# **Suffolk County Council (20031377)**

Answers to Examining Authority's Questions 2 (ExQ2)

## **Sunnica Energy Farm (EN010106)**

**13 January 2023**

SUNNICA EAST SITE B,
SITE ACCESS I (SE-I)
NEWMARKET ROAD

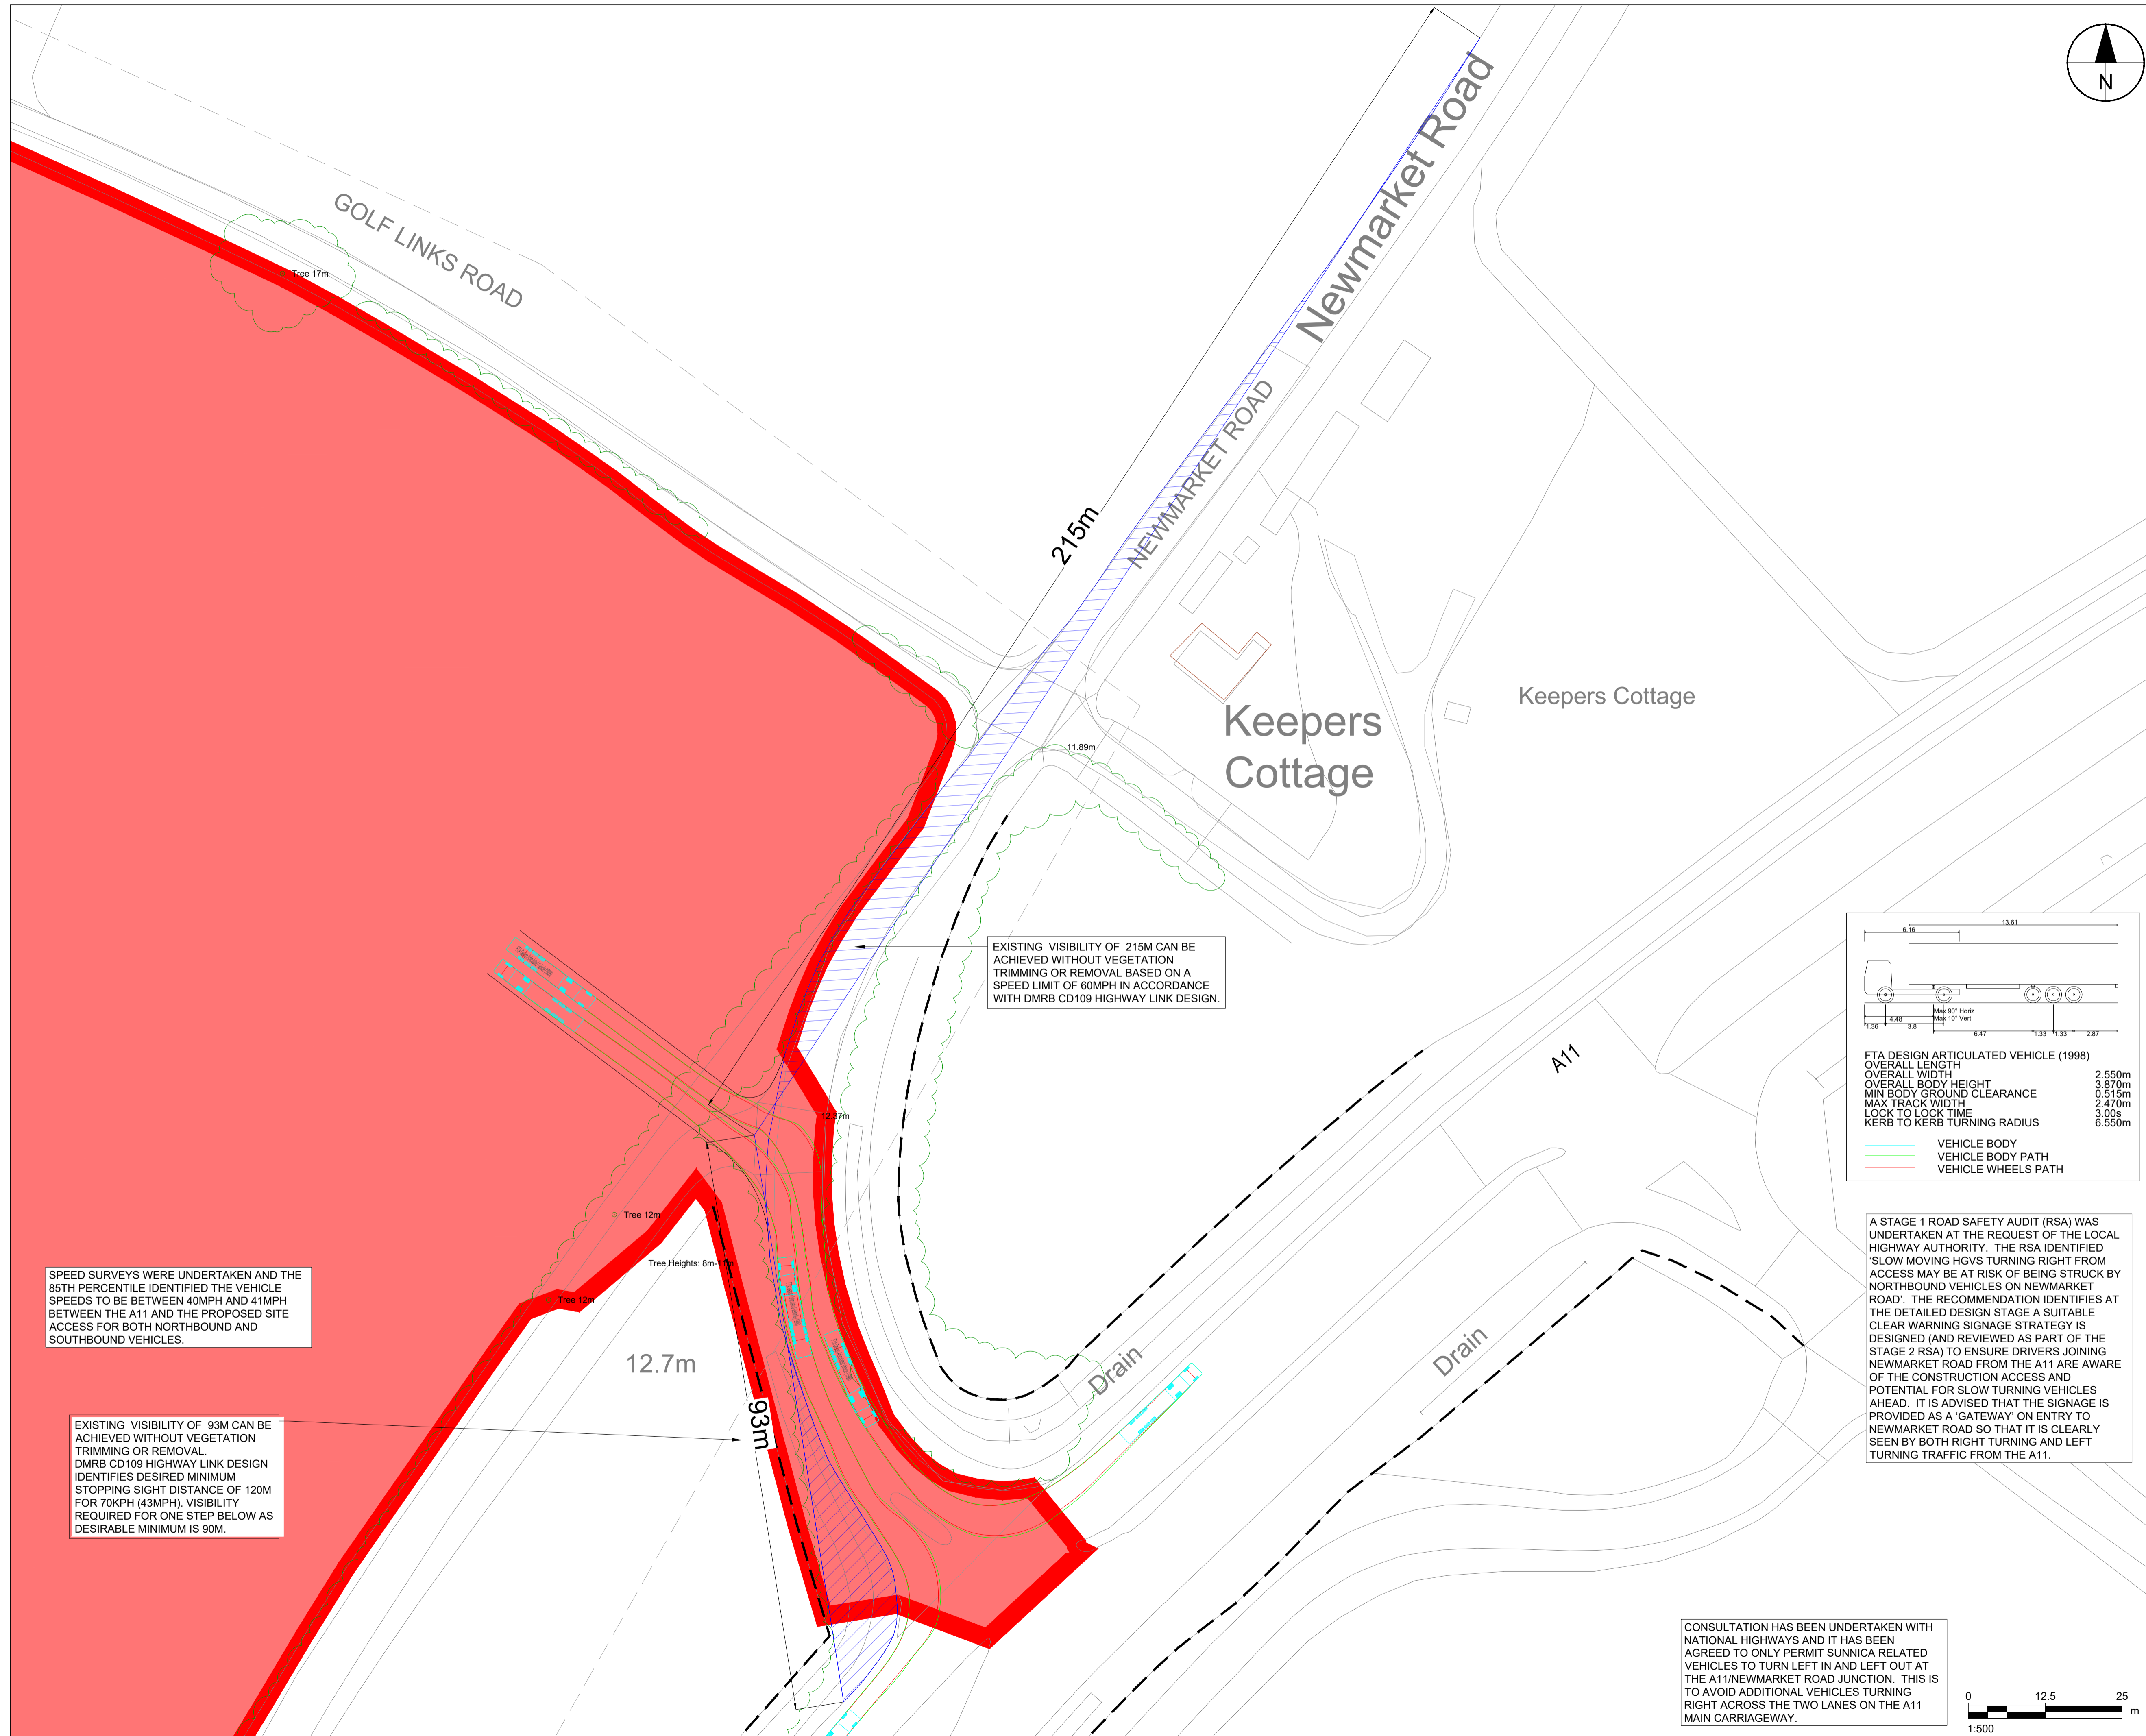
ExQ2	Question to:	Question:	SCC Answers:
Q2.10.1	The Applicant	<b>General</b>	
Q2.10.2	The Applicant	<b>General</b>	
Q2.10.3	The Applicant	<b>Access to Sunnica East Site B</b>	
Q2.10.4	The Applicant	<b>Abnormal load access to Burwell National Grid substation</b>	
Q2.10.5	The relevant highway authorities	<p><b>Site access and crane routes</b></p> <p>In your joint response to our ExQ1.10.45 and 1.10.46 [REP2-078], you express reservations about various issues relating to site access and crane routes, including road widths, the use of Manual for Streets on high speed rural roads and a post consent crane access route review.</p> <p>Are you satisfied with the Applicant's response [REP3A-036] to the concerns you raise? If not, what issues are outstanding, and are they capable of satisfactory resolution?</p>	<p>AIL access from A11 / A14 to site: A number of matters of detail remain to be resolved e.g., the over-run of the island at B1102 Mildenhall Road / U6003 Elms Road junction.</p> <p>SCC has, in principle, accepted the provision of passing places on Elms Road. This resolves the issue of MfS road widths for this location.</p> <p>SCC does not accept that the applicant has demonstrated that the proposed temporary traffic management proposals are safe and deliverable.</p> <p>SCC does not accept that the applicant has demonstrated that the site access layouts for use in the operational phase are safe (e.g., acceptable visibility).</p> <p>SCC does not consider that Access I is safe due to the limited visibility to the south.</p>
